17 December 2021
Job No: 20214_Response to Council_REV2

Re: Huntingwood Processing Facility – SSD 17352813 - 65 Huntingwood Drive, Huntingwood

We Sparks & Partners Consulting Engineers being the civil/stormwater engineer for the above proposed development have reviewed the comments provided by Council dated 16th November 2021 and provide the following responses regarding DPIE & Council concerns to assist in the SSDA assessment.

DA4311

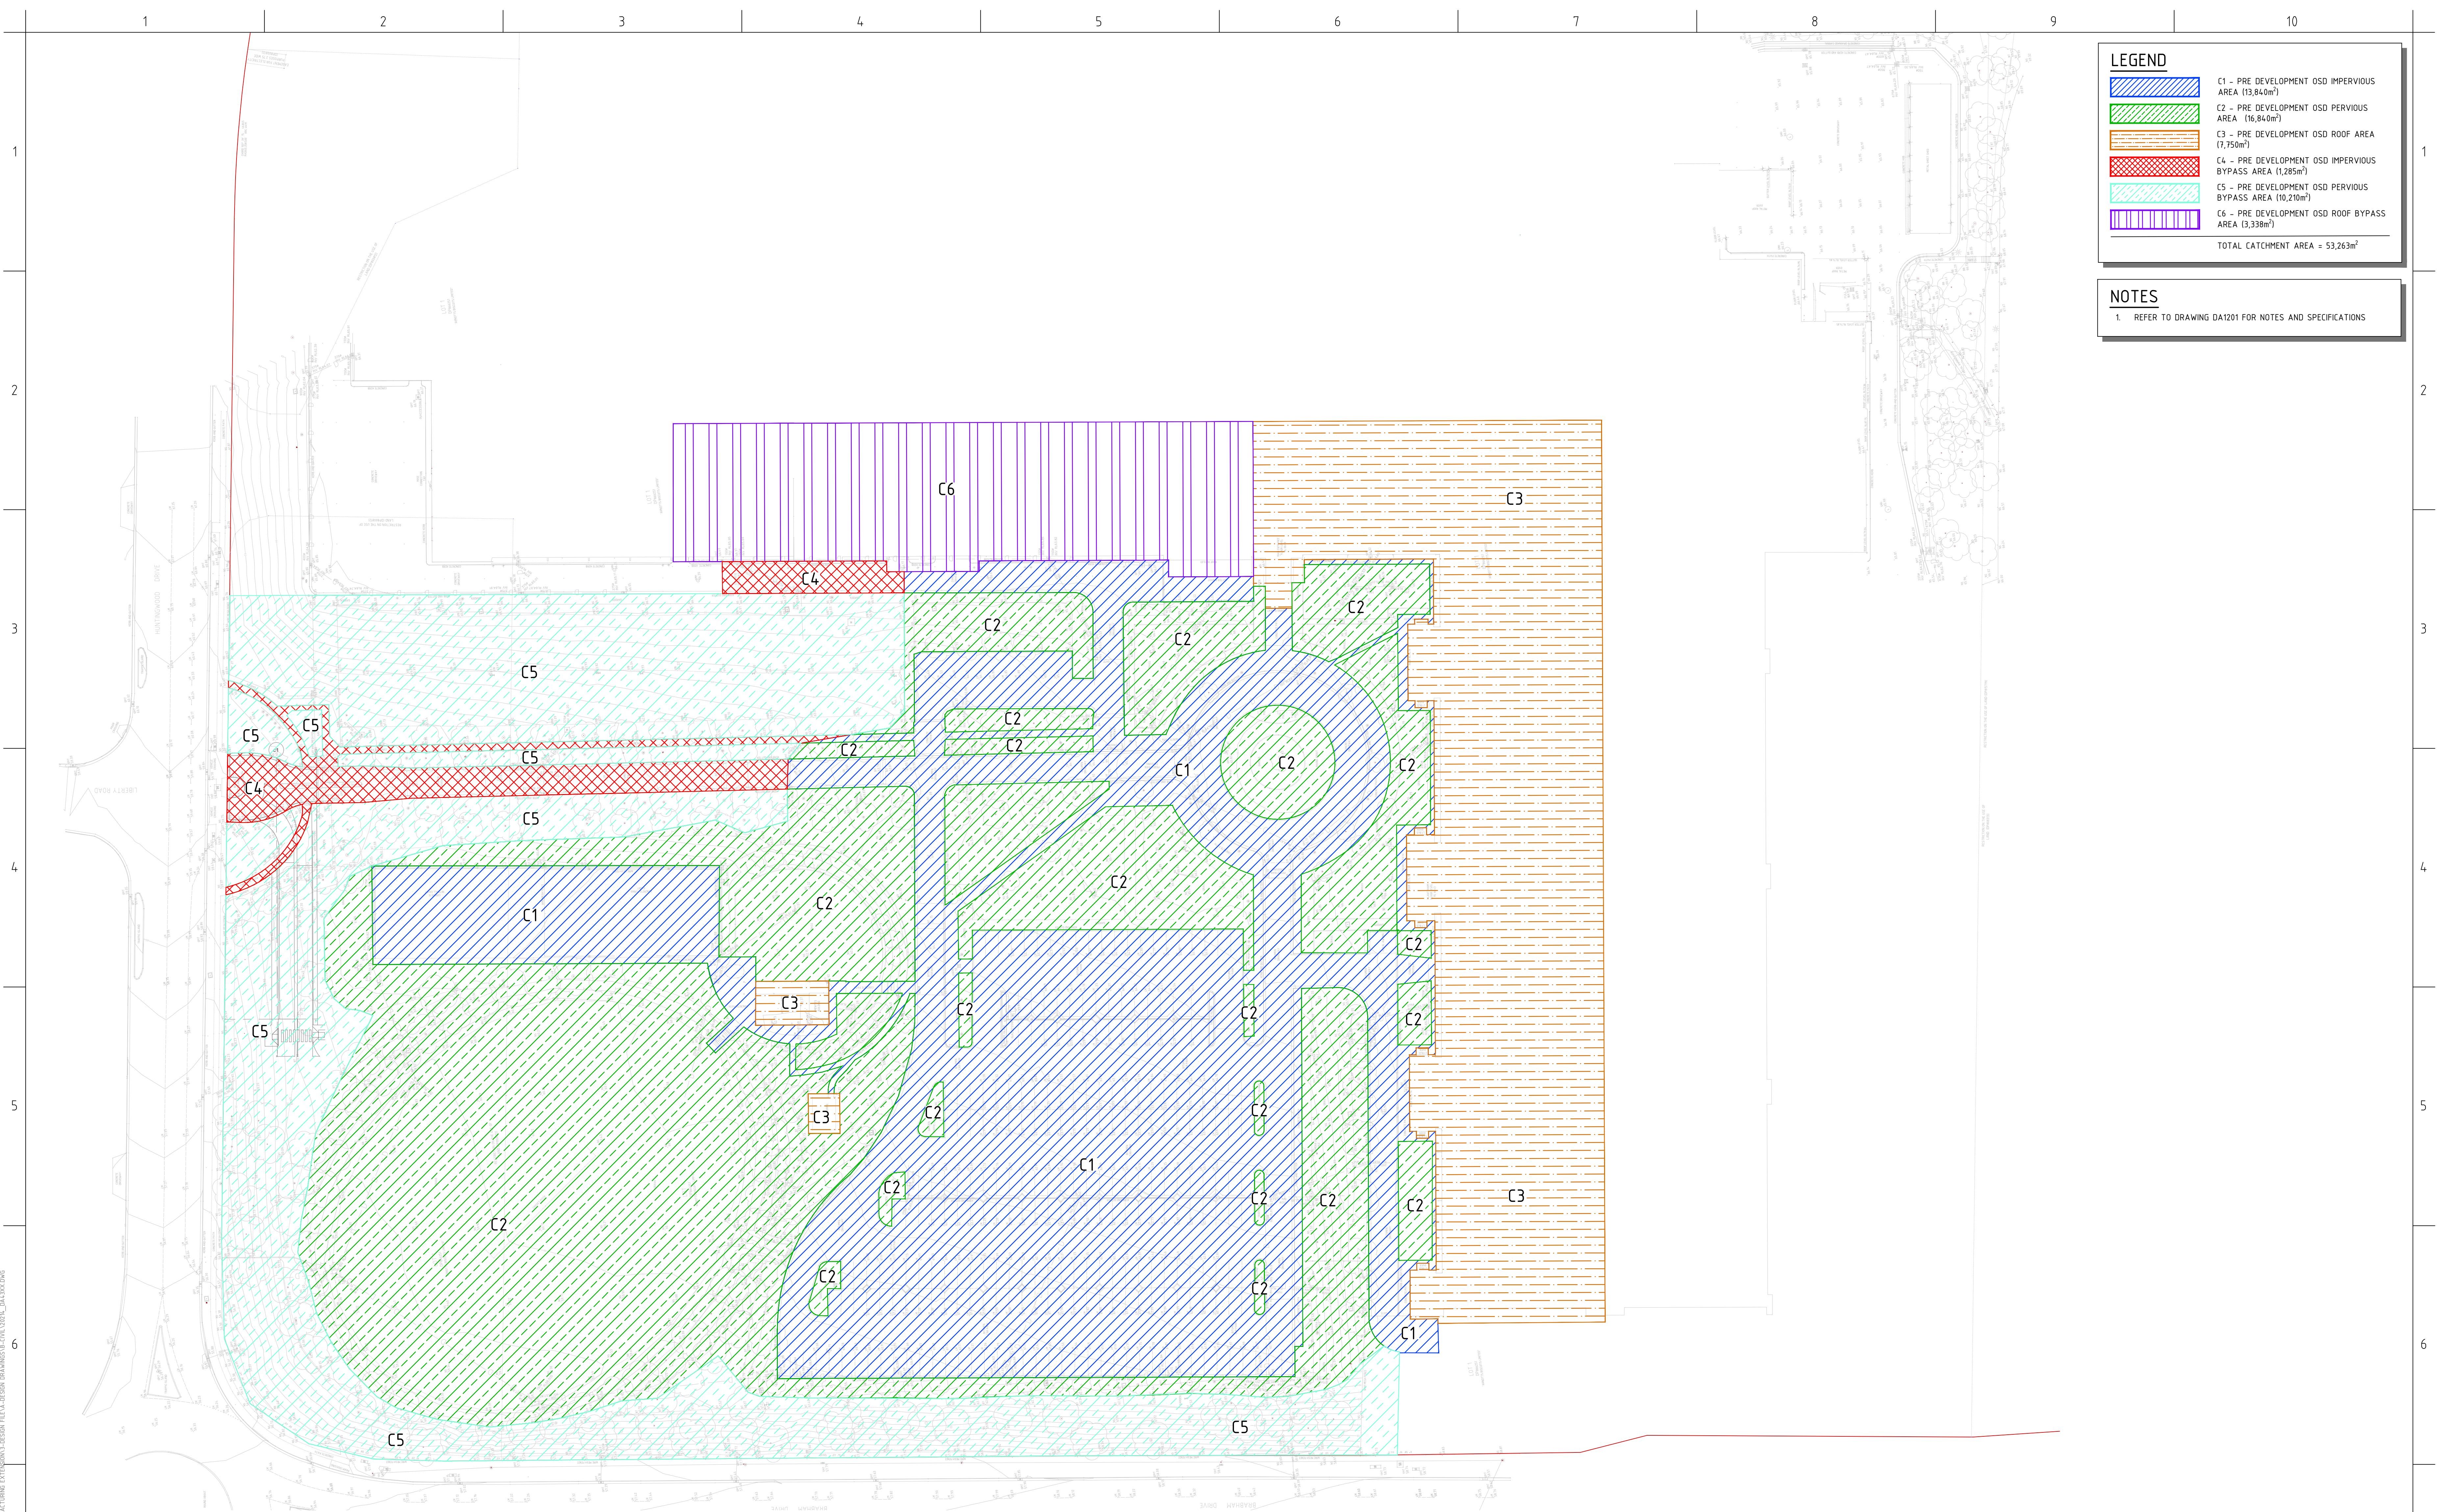
Comment	Response
On-site Stormwater Detention	
a) <i>Provide an On-Site Detention catchment plan of the existing On-Site Detention and the proposed On-Site Detention catchment. Considering the existing primary On-Site Detention is to be demolished the pre to post catchment should match. While the areas have been clearly stated in the integrated water report there is no catchment plan associated with this. The report and plans currently do not match and has to be fixed..</i>	<ul style="list-style-type: none"> • Catchment plan of existing OSD is provided as drawing DA4311. • Catchment plan of proposed OSD is provided as drawing DA4312.
